**Our Case Number:** ABP-314501-22

**An  
Bord  
Pleanála**

**Date:** 13 February 2023

**Re:** South Dublin Street and Backlands Regeneration Project. The proposed development covers an area of approximately 2.72 hectares and comprises urban regeneration and public realm proposals. Properties at 7- 13 Dublin Street, lands to the rear of 1-9 The Diamond and 1-26 Dublin Street, the Courthouse car park, Lower Courthouse car park, Castle Road, and N54 Macartan (Broad) Road, townlands of Roosky and Tirkeenan, Co. Monaghan

**MGT0528-
RPS-00-XX-
DR-C-DR1001
- Drainage
(Planning Issue)**

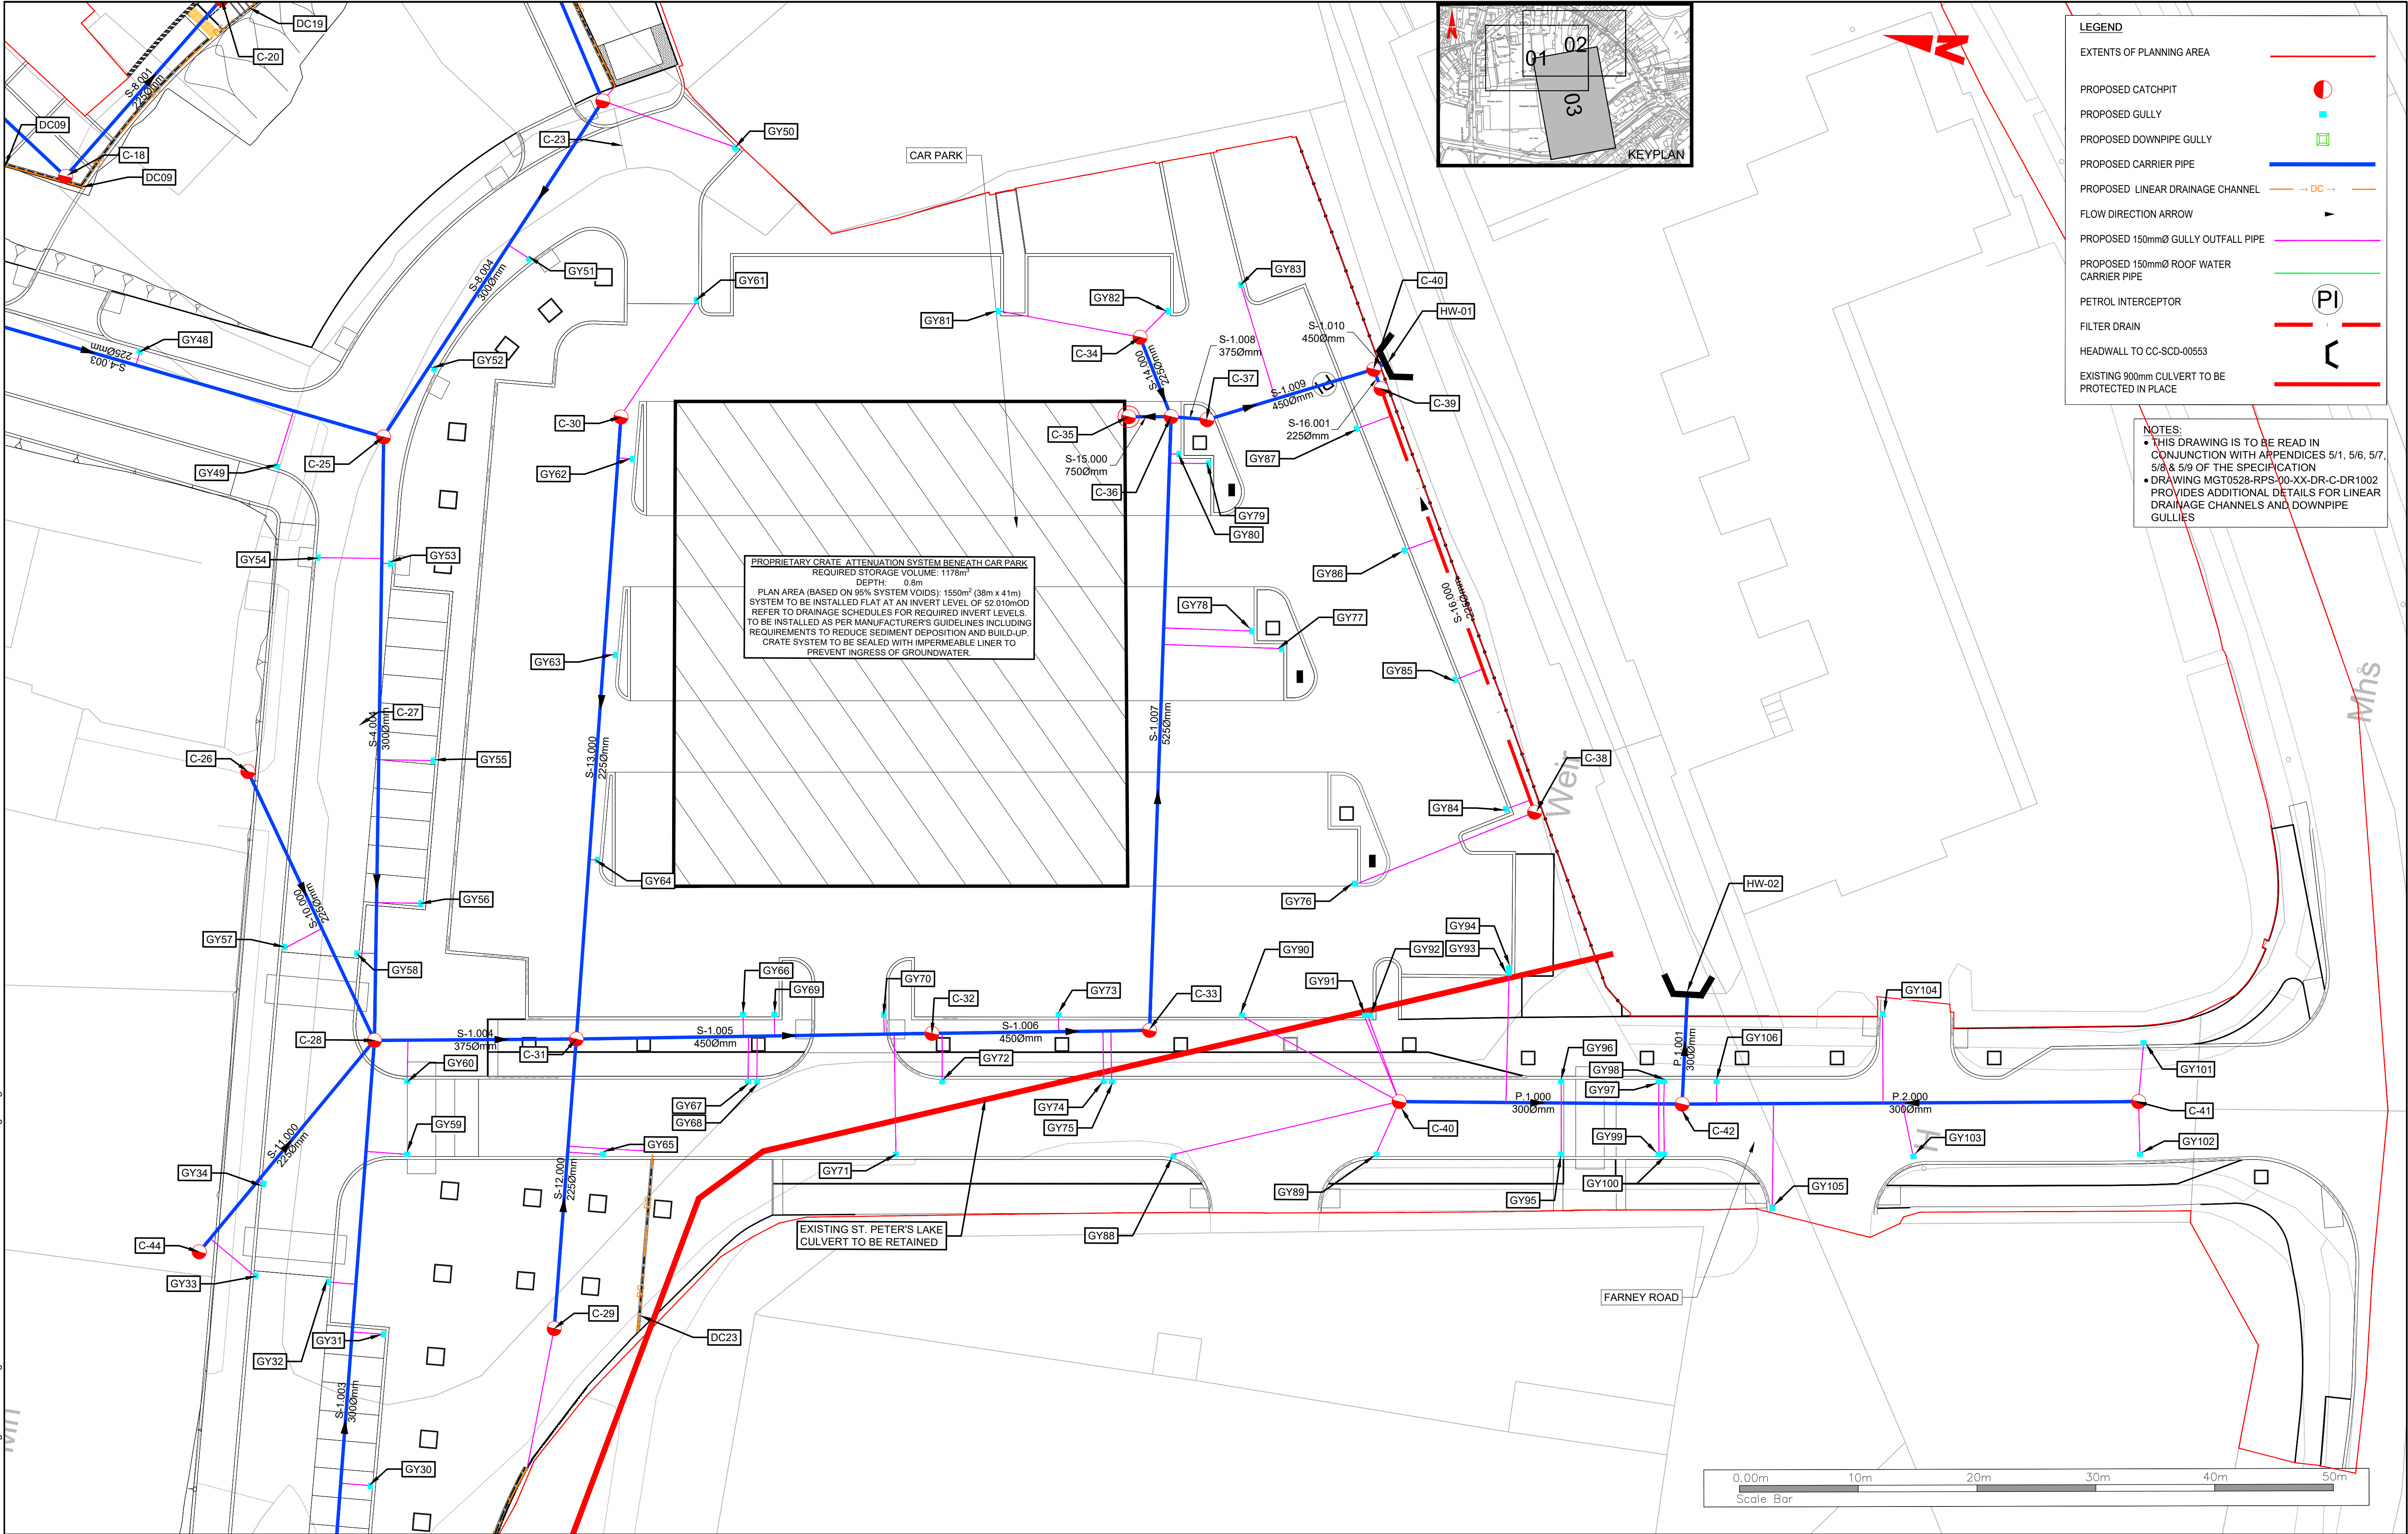
- (a) Table 6.8 is a repeat of Table 6.9: summary of Ortho-Phosphate. Please submit the correct Table 6.8 Summary of Total Oxidised Nitrogen, and include a statement as to whether or not the levels are indicative of high or good quality or otherwise.
- (b) The Drainage Layout Map, drawing no. DR1001 does not indicate the proposed water or sewerage network. Please submit a site layout plan detailing these proposed networks.
- (c) Submit a site layout plan indicating existing service networks in the site, to include water and sewerage.
